From: Joanne Lewis [REDACTED]
Sent: 12 September 2019 09:23
To: Planning.Responses <Planning.Responses@arun.gov.uk>
Subject: RE: Planning Consultation on: LU/240/19/PL

APPLICATION NO: LU/240/19/PL

Site Address: Littlehampton Trades And Labour Club Wick Street Littlehampton
BN17 7JH

Description of Works: Change of use of part of car park to a beer garden.

PROPOSED PLAN
Scale 1:50

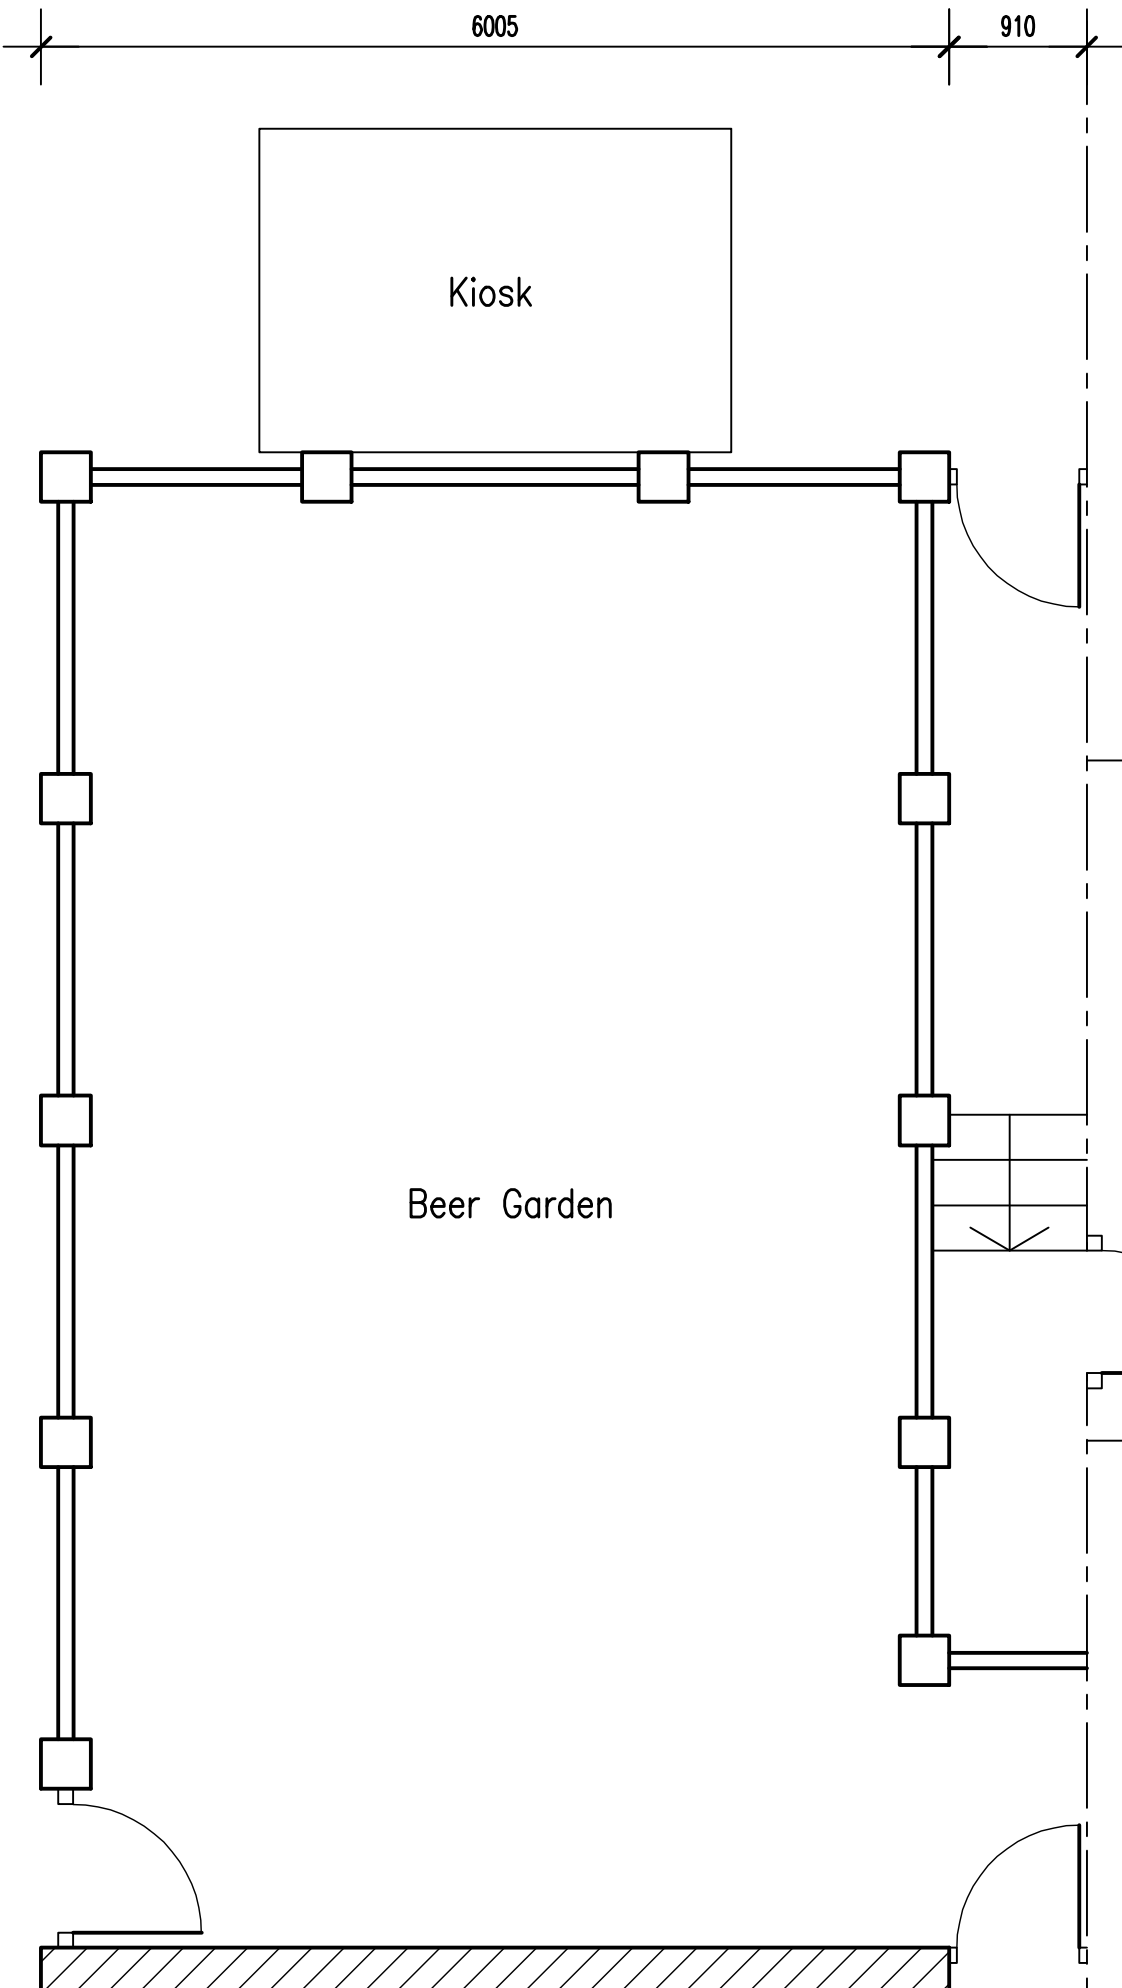
The proposal involves creating a beer garden immediately adjacent to the rear garden of a number of local residents, with use proposed for a large part of the day and into the evening. I therefore have concerns about noise from the patrons causing a nuisance to nearby residents.

The application also shows a kiosk but there is no mention of what purpose this serves and whether it is related to the beer garden. If it is serving food, drinks or entertainment this will increase the noise levels in the garden and the potential for disturbance.

There is no information in the application on the number of people that will be permitted to use the garden and no information on how noise will be monitored or controlled and complaints from neighbours dealt with, particularly given that the site is not immediately to the rear of the club building. Without this information I would be minded to object to the application on the basis of potential nuisance to nearby residential occupiers. However if the applicant is able to provide the additional information requested I would be happy to review this.
